Please ask for: Ms Iqraa Malik
Email: iqraa.malik@terraquest.co.uk
Telephone: 0121 234 1390
Our Ref: M/132/21/HH
Your Ref:
Date: 14th October 2021

Application for Planning Permission for Works or Extension to a Dwelling

Development: Erection of part single, part two storey side extension and single storey other side extension following the demolition of sun room and conservatory
Location: 12 South Walk Middleton-On-Sea PO22 7RW

LOCATION PLAN AND BLOCK PLAN
DATE: OCTOBER 2021
SCALE: 1:1250 @ A3 1:500 @ A3
JOB No. 1118
DRWG No. 100 Rev. A

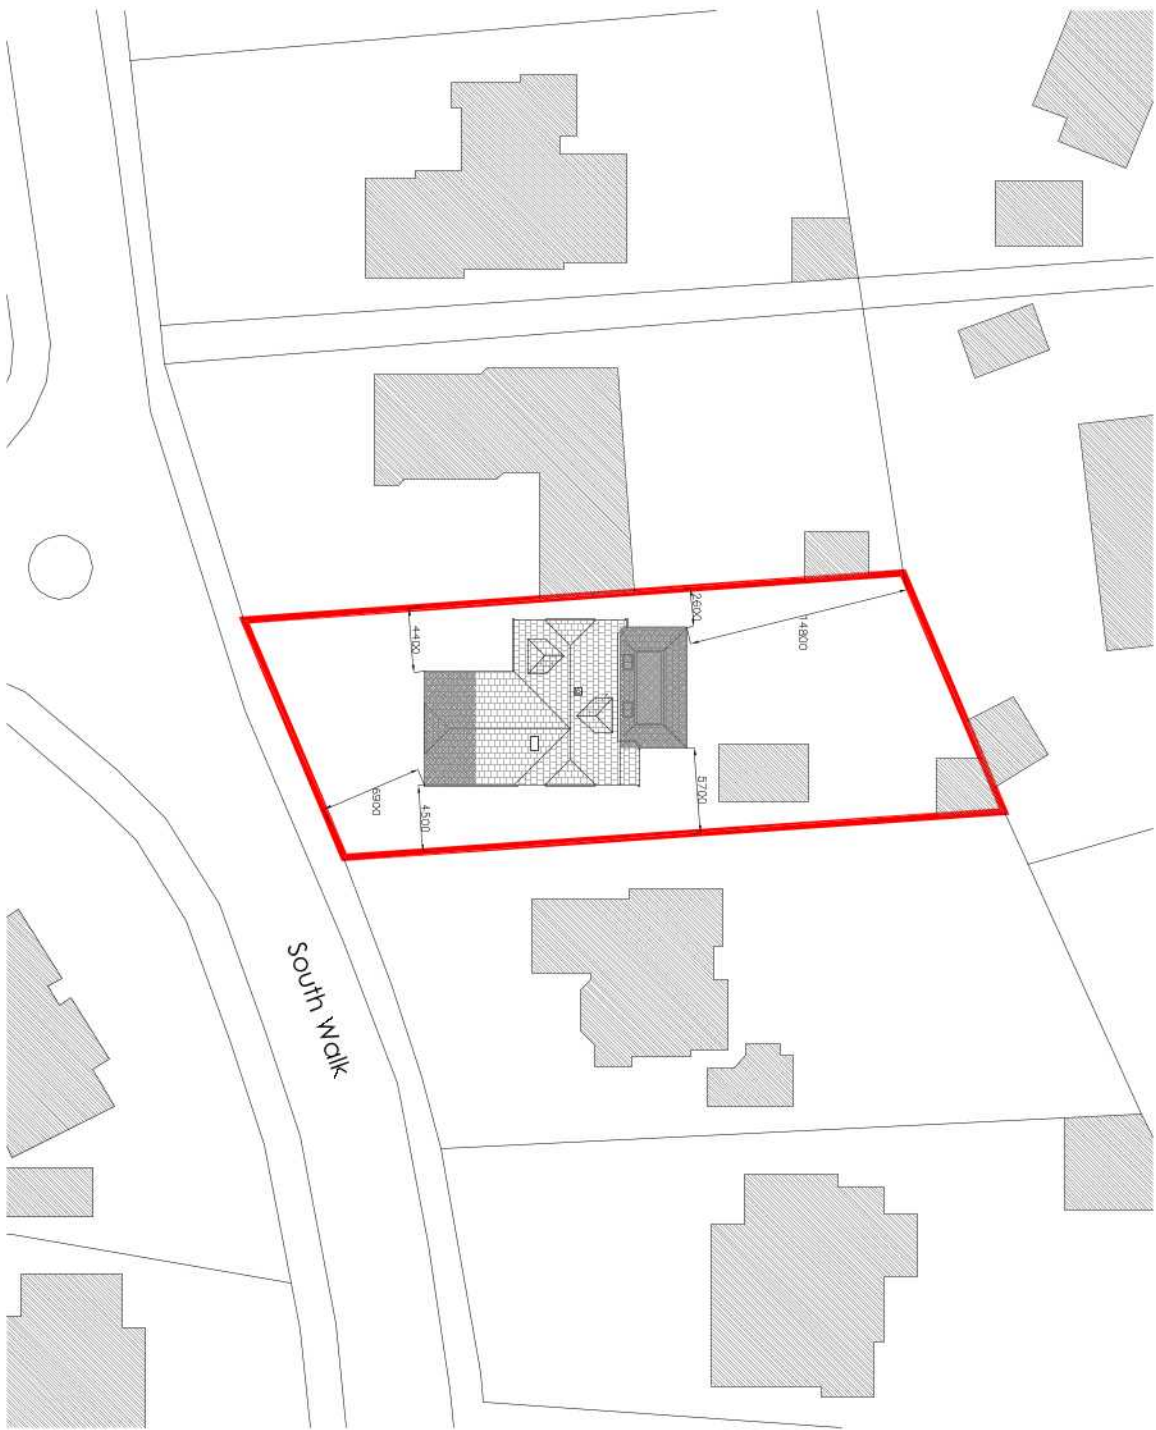
Erection of part single, part two storey side extension and single storey other side extension following the demolition of sun room and conservatory
Block Plan

You are required to have dimensions from the proposed extension(s) to all site boundaries. Please amend.
